RE: Responses to Comments on the Traffic Impact Study for the Haven School

El Paso County provided comments on the traffic impact study for this project that was dated August 25, 2023. Sustainable Traffic Solutions has responded to the comments as noted below.

## Comments received from El Paso County on October 15, 2023

# Haven School

Figure 22 – Intersection Sight Distance at the Site Access on Burgess Road

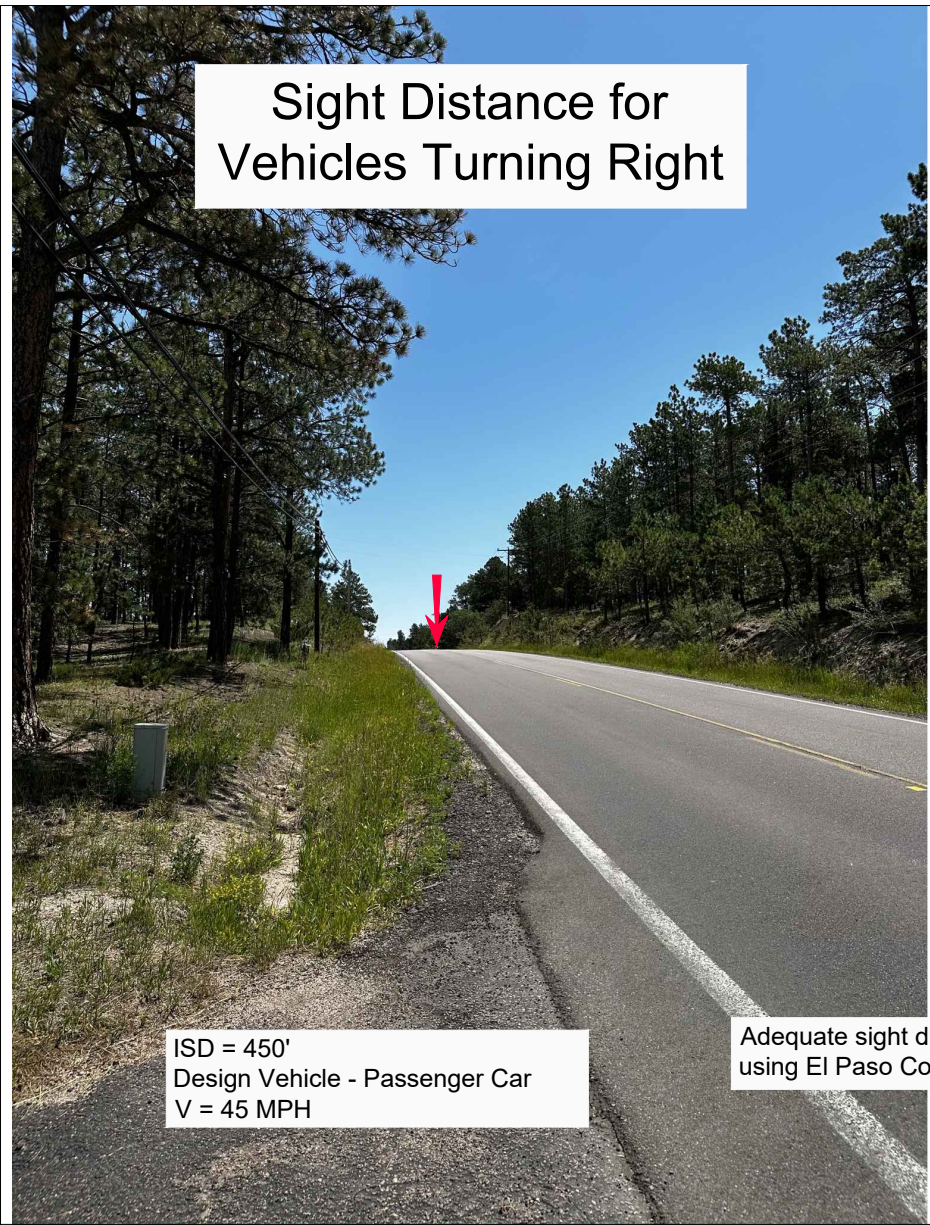
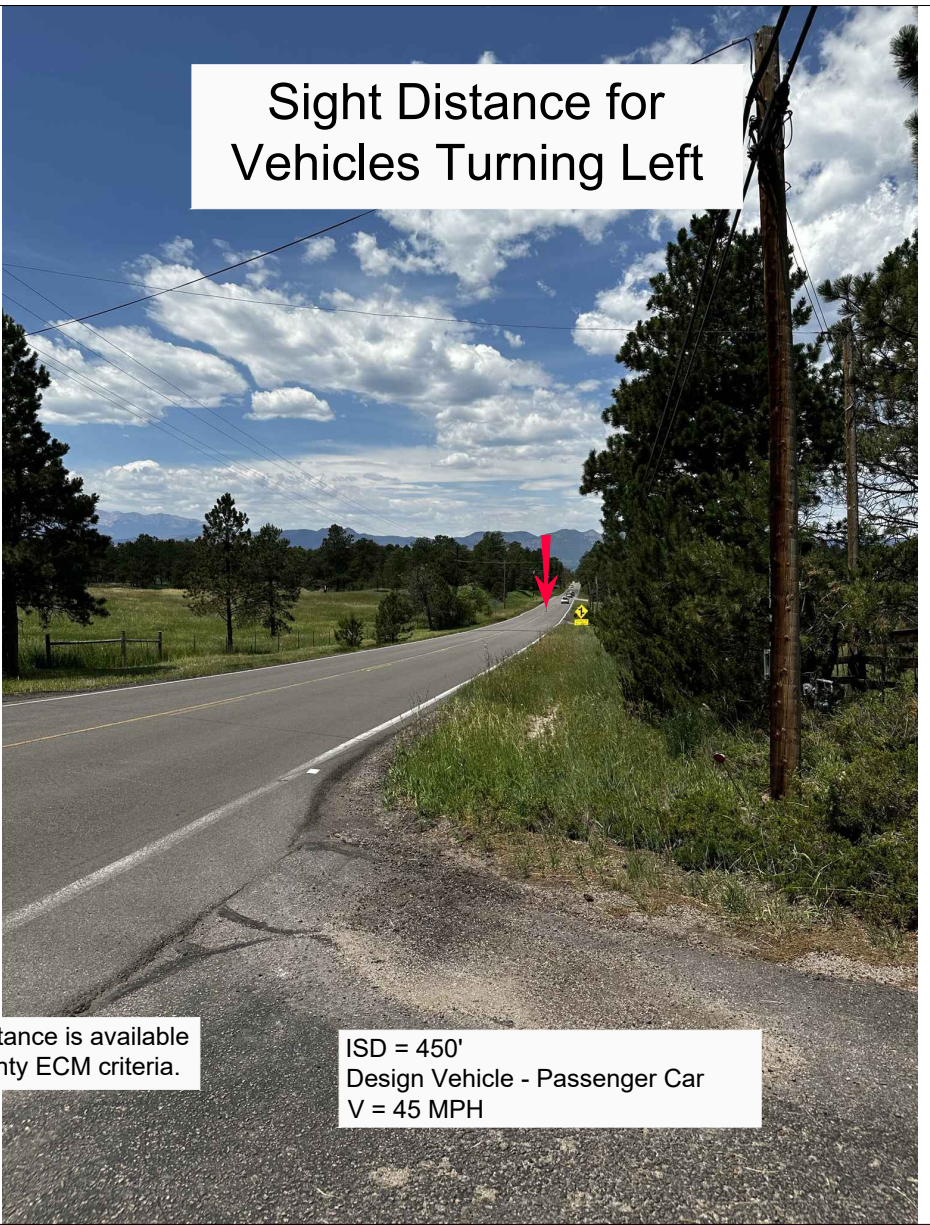
**Comment 13** Please state in the text what the ECM sight distance criteria are and state whether they are met.

**Comment 14** Design Vehicle Selection per ECM Table 2-36 shall be single unit truck for a school bus type route. For a school entity a school bus can be expected. Update sight distance and submit a deviation if not met.

**Response** The change was made.

**Response** The entering sight distance was only verified for the passenger vehicle because buses and trucks are not expected to use the access based on information provided by the Haven School. Considering the vertical geometry, there isn't enough sight distance to accommodate a school bus.
